Please ask for: Nicola Moore
Email: nicola.moore@arun.gov.uk
Telephone: Ext 37944
Our Ref: LU/263/21/PL
Your Ref:
Date: 13th September 2021

Application for Planning Permission

Development: The construction of a two-storey office building (Use Class E).
Location: Land At Unit 4 Hawthorn Road Hawthorn Road Littlehampton BN17 7LT

No.	Description	Date
Client: Chico & Mash		
Address: Unit 4 Hawthorn Road, Littlehampton.		
Project: Proposed Office Building		
Drawing title: Site Location Plan		
Project No		18107
Date		20-12-19
Drawn by		IA
Drawing No		SLP01
Scale1:1250@A3

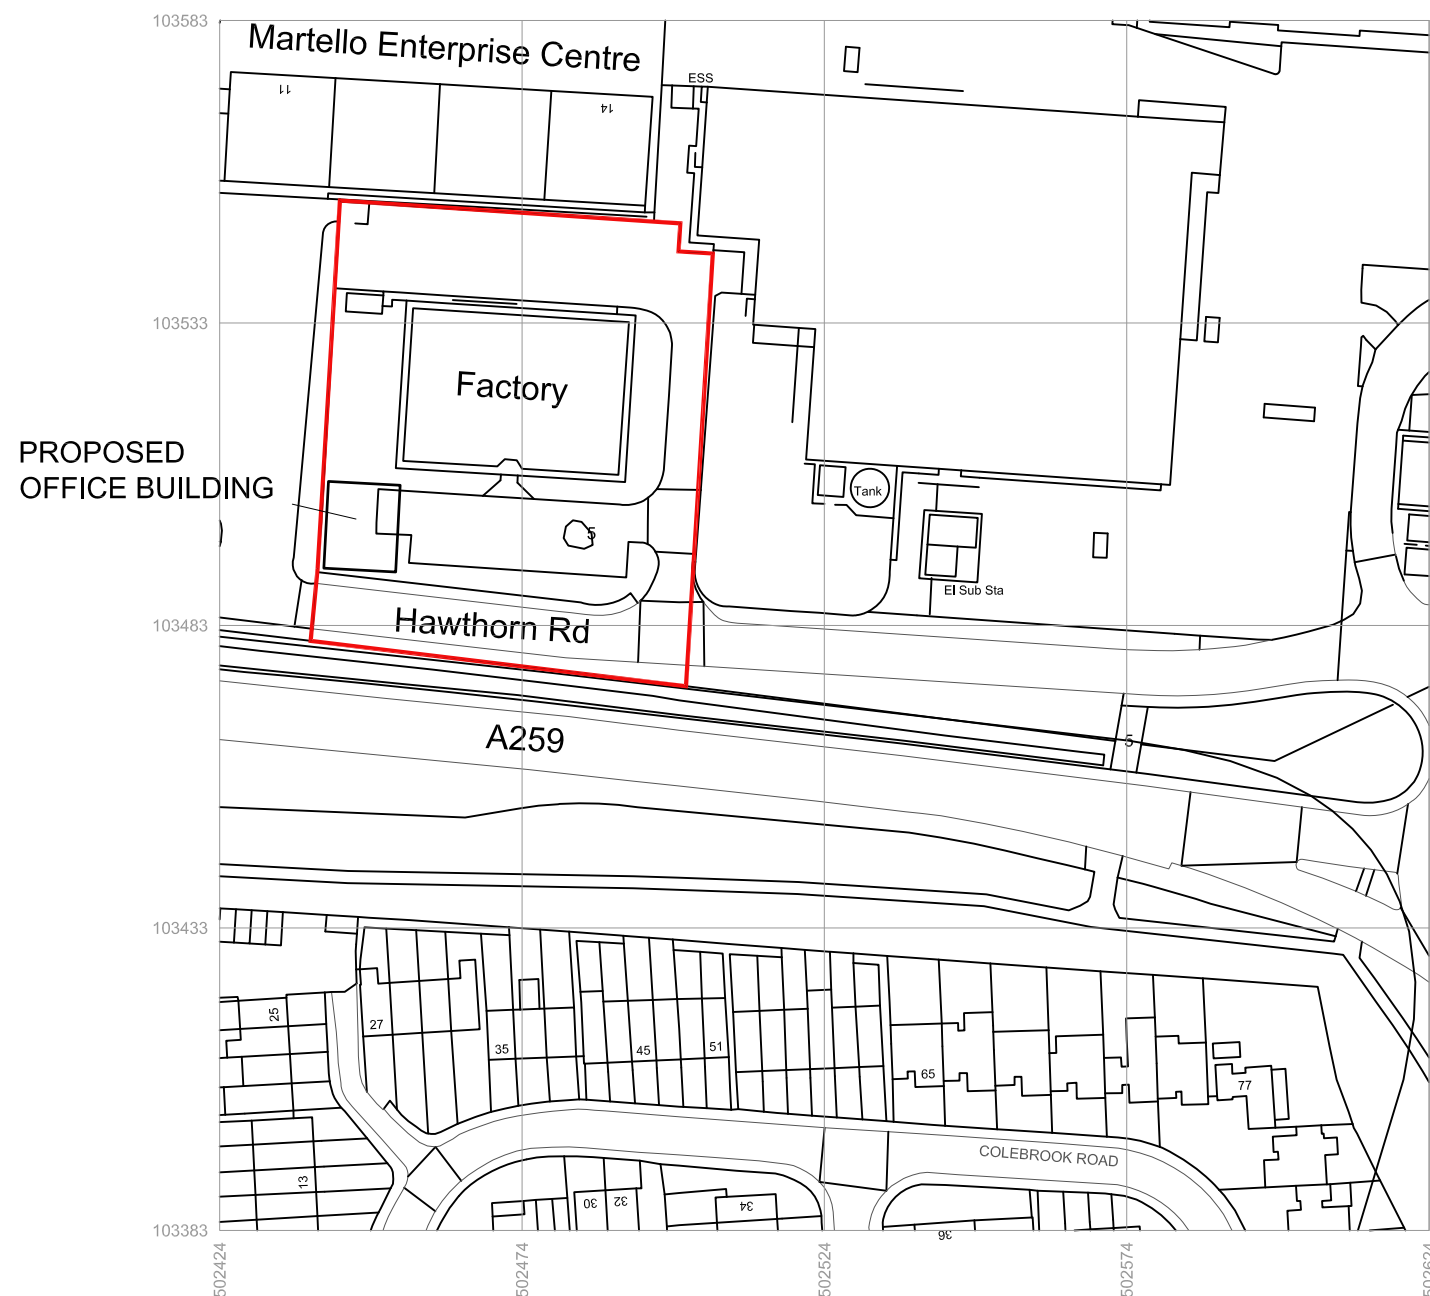
The Location Plan should have a red edge around the application site. Please amend accordingly and re submit at a scale of 1:1250 or 1:2500 for rural areas. Further details of what must be included on the plan can be found in the Validation Requirements List.
